Application Ref: H08-1263-25

Proposal: **Barn conversion to single dwelling**

Location: **Belnie House Farm Building,s Belnie Lane, Gosberton, Spalding, PE11 4HN**

PROPOSED SITE PLAN 1:250

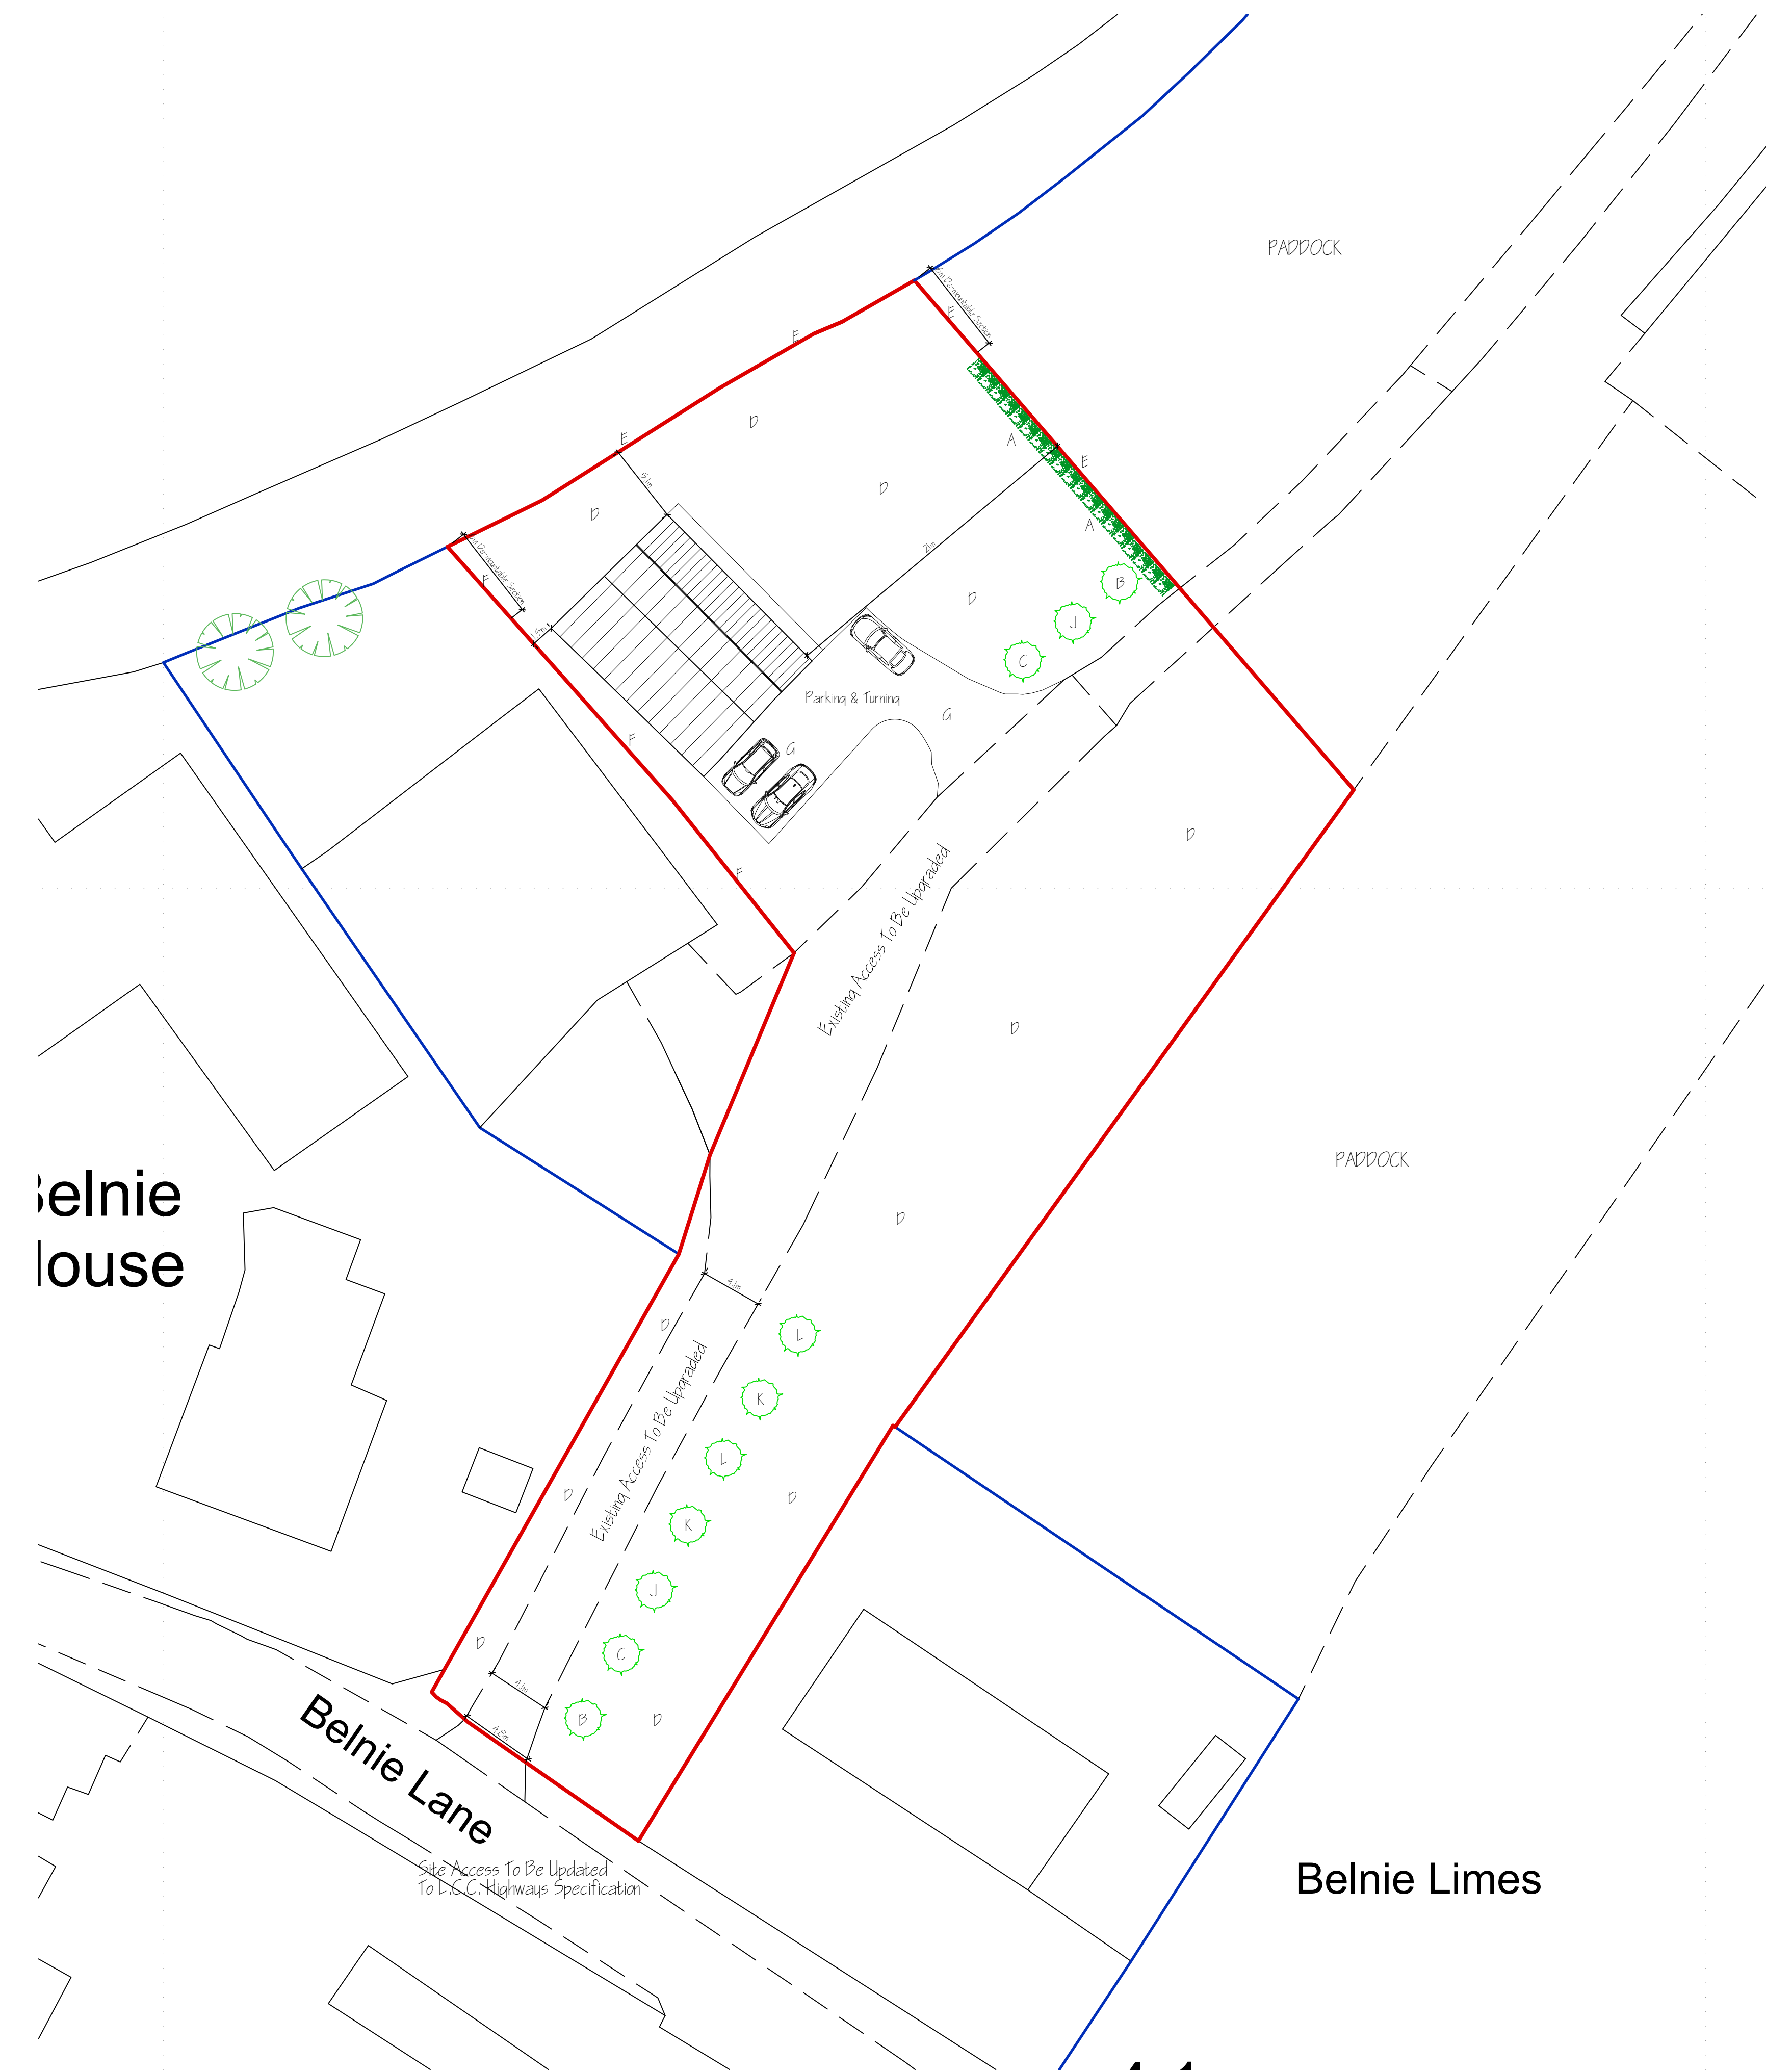
Parking spaces and turning need to be detailed. For a 3 bed house two parking spaces should be provided.
